DRAINAGE INFORMATION SHEET

PROJECT TITLE: VANGUARD PRINTING ZONE ATLAS/DRNG. FILE #: J-14/D121
 DRB #: 97-172 EPC #: _____ WORK ORDER #: _____
 LEGAL DESCRIPTION: LOT 25-A, BLOCK 13, PARIS ADDITION
 CITY ADDRESS: 101 SUMMER AVE. NW
 ENGINEERING FIRM: RHOMBUS P.A., Inc. CONTACT: CELIA TOMLINSON
 ADDRESS: 2620 SAN MATEO NE SUITE B PHONE: 881-6690
AND 8TH
 OWNER: VANGUARD PRINTING CONTACT: MARTY CARRAHER
 ADDRESS: 101 SUMMER NW PHONE: 242-5426
 ARCHITECT: JACK HARRIS ARCHITECTS CONTACT: JACK HARRIS
 ADDRESS: 4706 LOMAS NE PHONE: _____
 SURVEYOR: RHOMBUS CONTACT: JOHN MIERS
 ADDRESS: 2620 SAN MATEO NE SUITE B PHONE: 881-6690
 CONTRACTOR: NONE CONTACT: NONE
 ADDRESS: NA PHONE: NA

Ref: Vanguard Printing File No. J14/D21

I have reviewed your drainage plan dated 4/22/97 for a building permit and submit the following comments:

## DRAINAGE AND GRADING PLAN

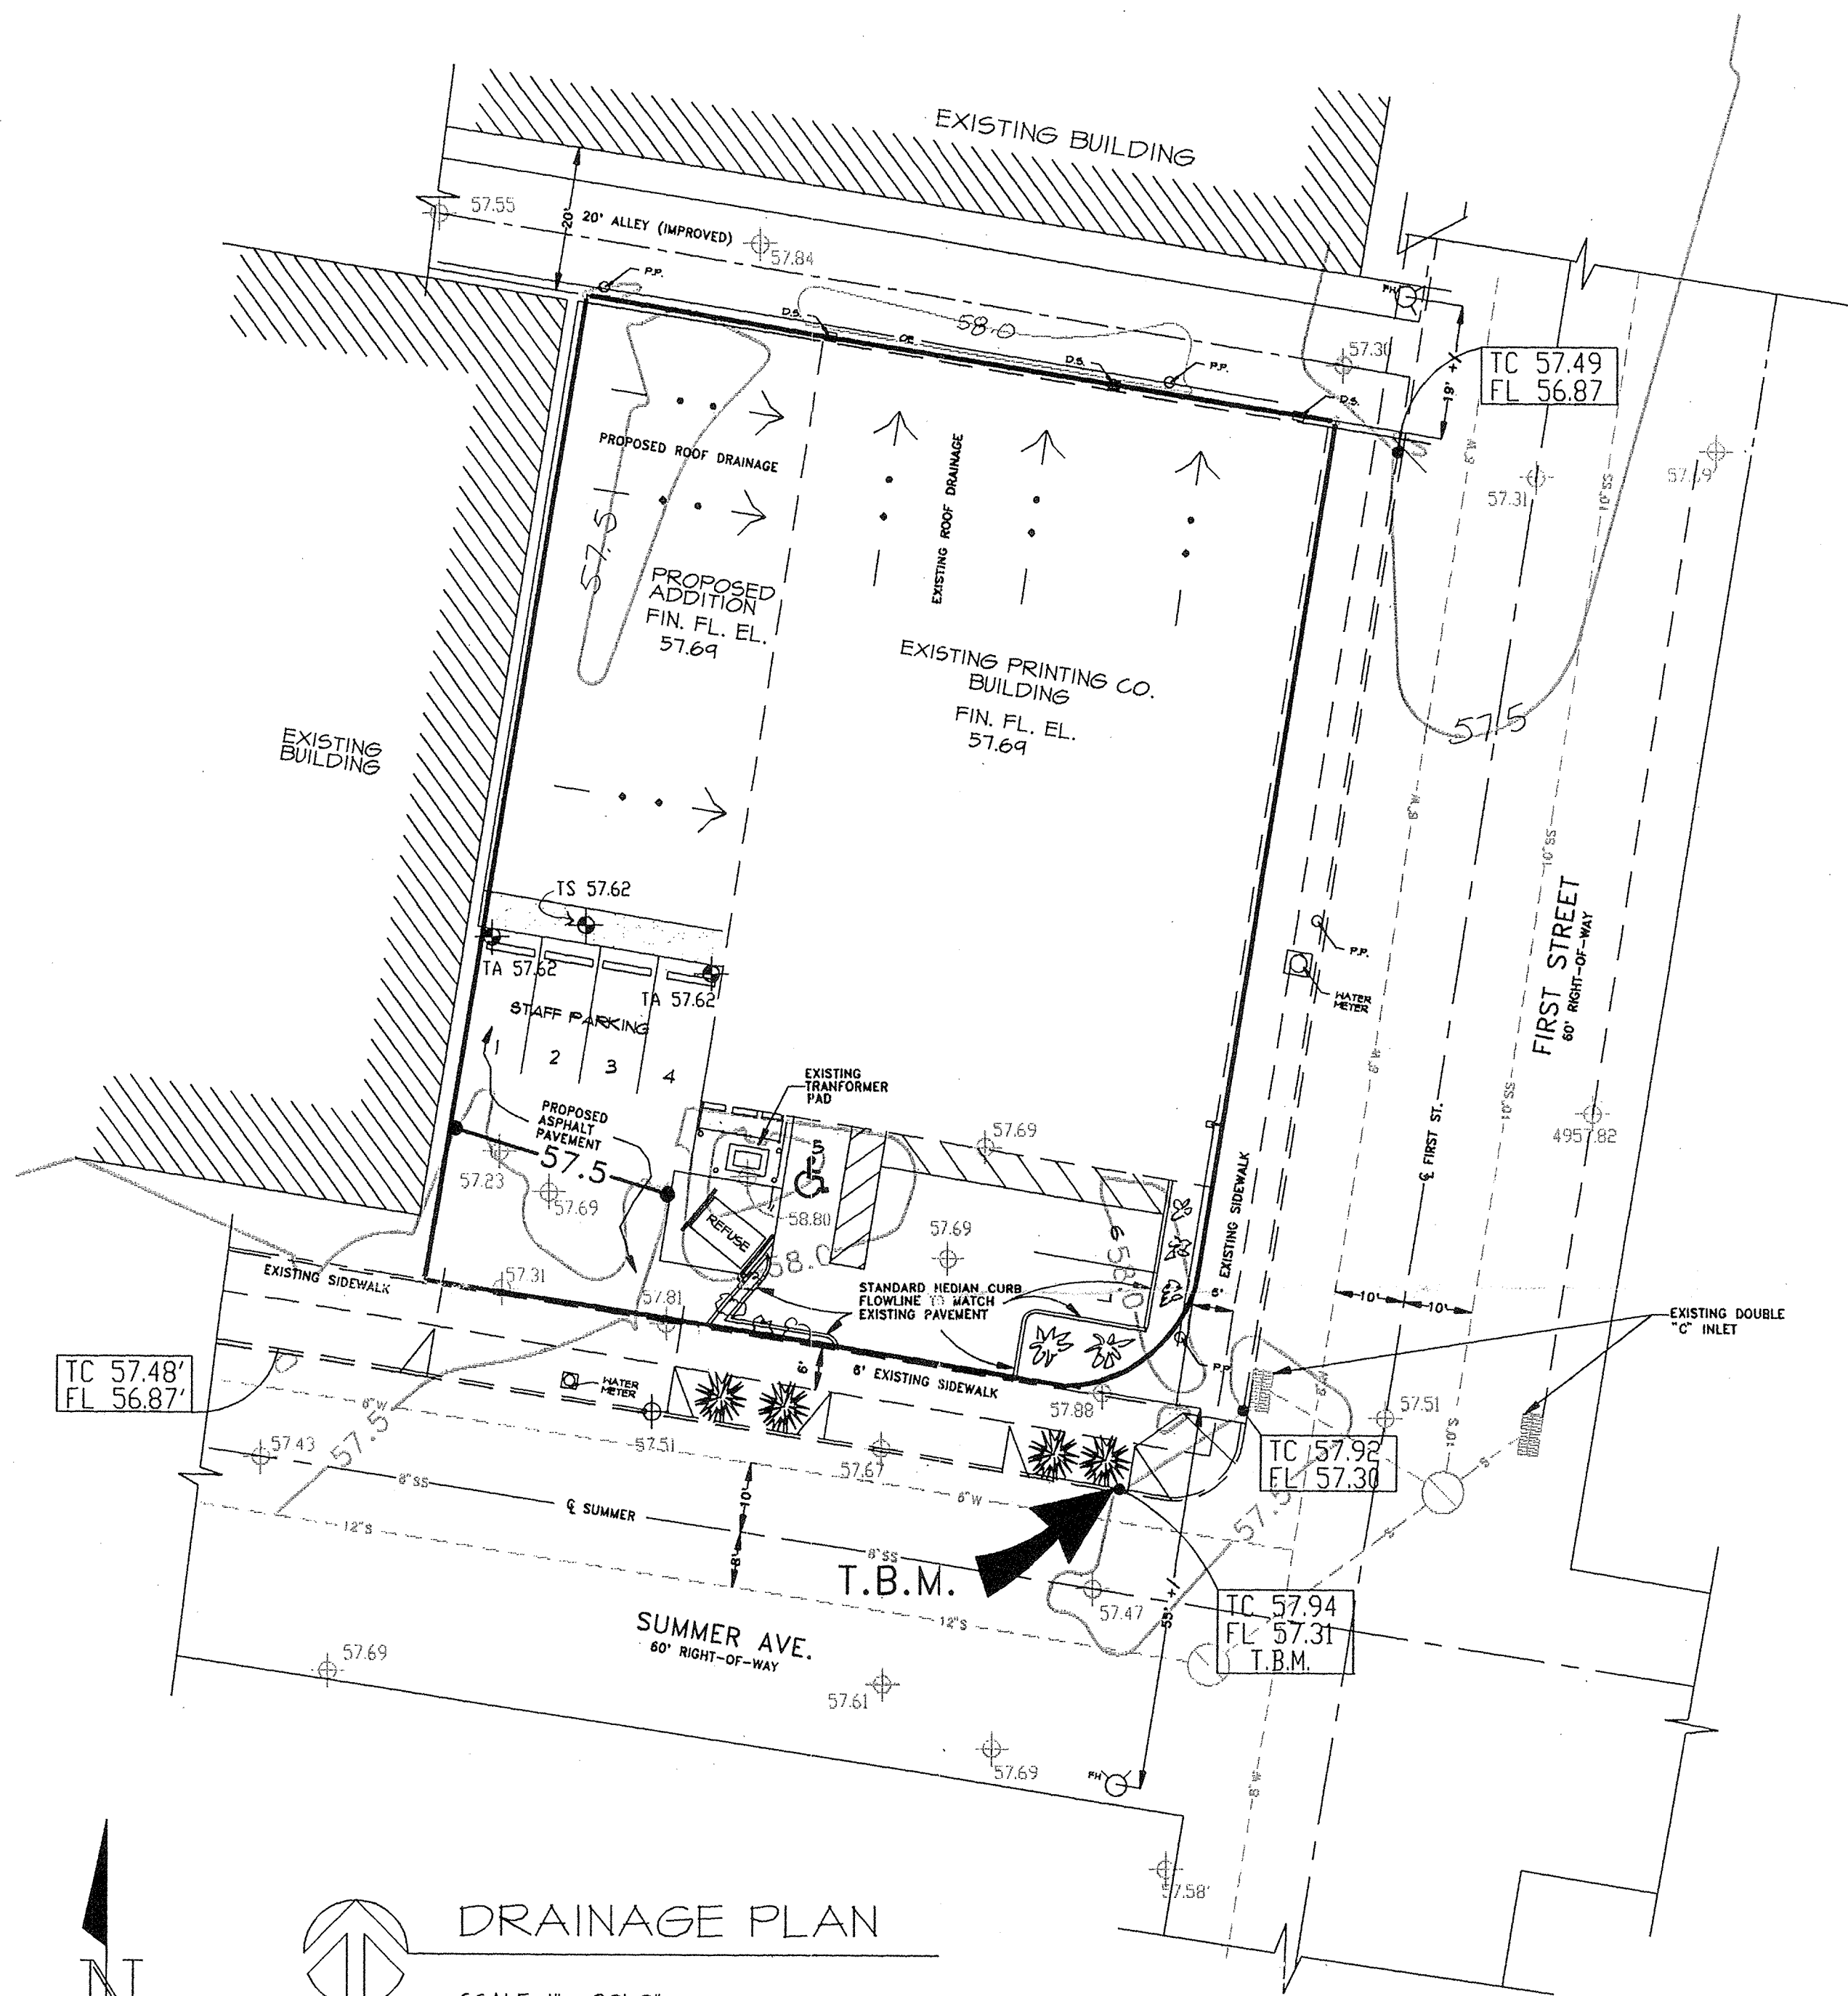
1. Will the increase flows to the alley be contained within the alley? Please address this question on the drainage plan.
2. Please provide the proposed and existing M.S.L. grades for the new curb and gutter and drivepads. Note: the finish grade at the property line must be 0.33' above top of curb per the City of Albuquerque Standard Specifications Drawings.
